KITTITAS COUNTY

MEMORANDUM

TO: All Staff
FROM: Public Works Plan Review Team
DATE: October 2, 2024
SUBJECT: SPF-24-00010 Carr

CARR SHORT PLAT

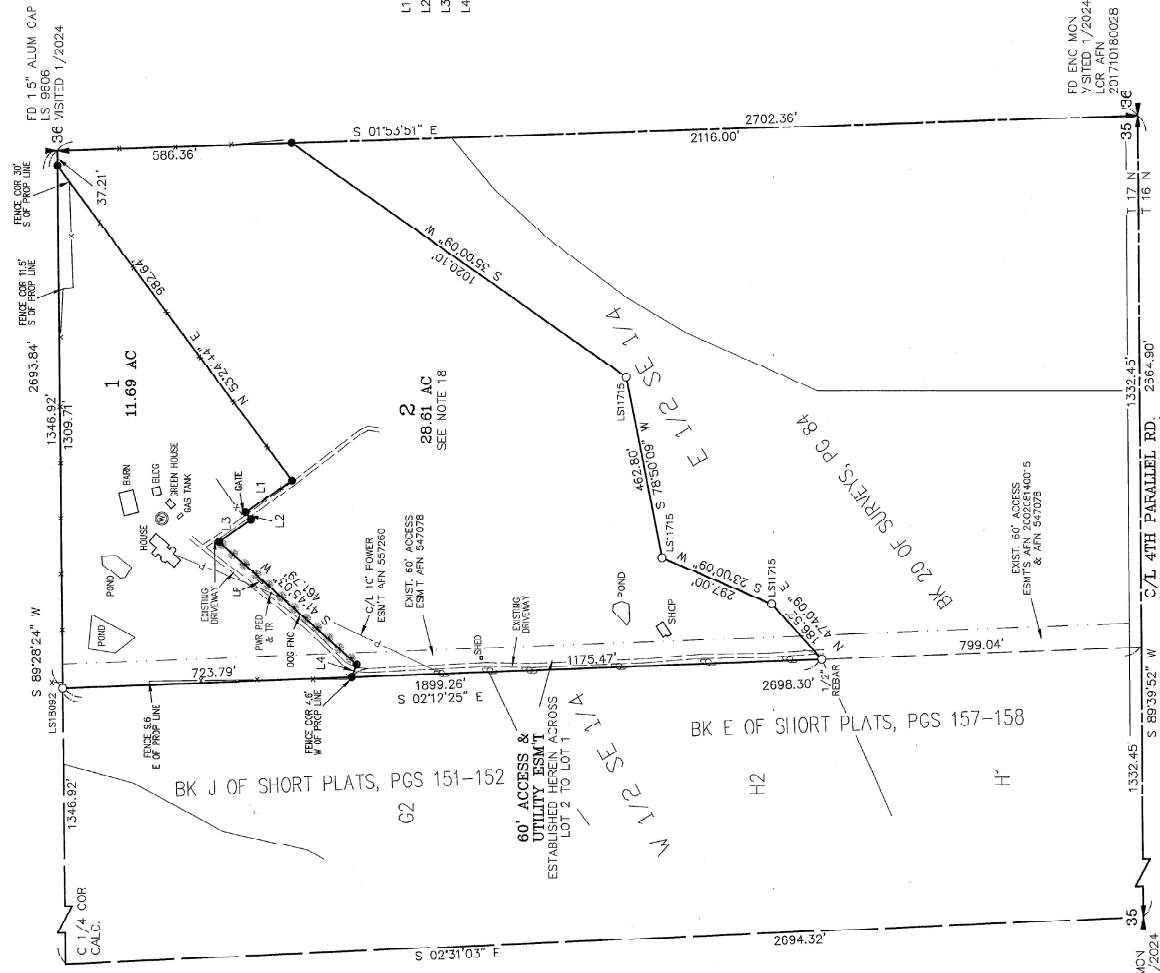
WATER MITIGATION/ METERING	<p>A plat note must be added for the conservation easement:</p> <p>LOT 2 OF THIS SHORT PLAT HAS BEEN PLACED IN A CONSERVATION EASEMENT RECORDED UNDER AFN 202409090025, THAT STATES LOT 2 SHALL BE USED FOR OPEN SPACE AND NO DOMESTIC WATER CONSUMPTION OR USE SHALL OCCUR. SEE DOCUMENT FOR FULL DETAILS.</p> <p>Please also include a note on the face of the plat in lot 2 that states: see short plat note <u>(insert number here)</u></p>
AIRPORT	No comments. (JS)
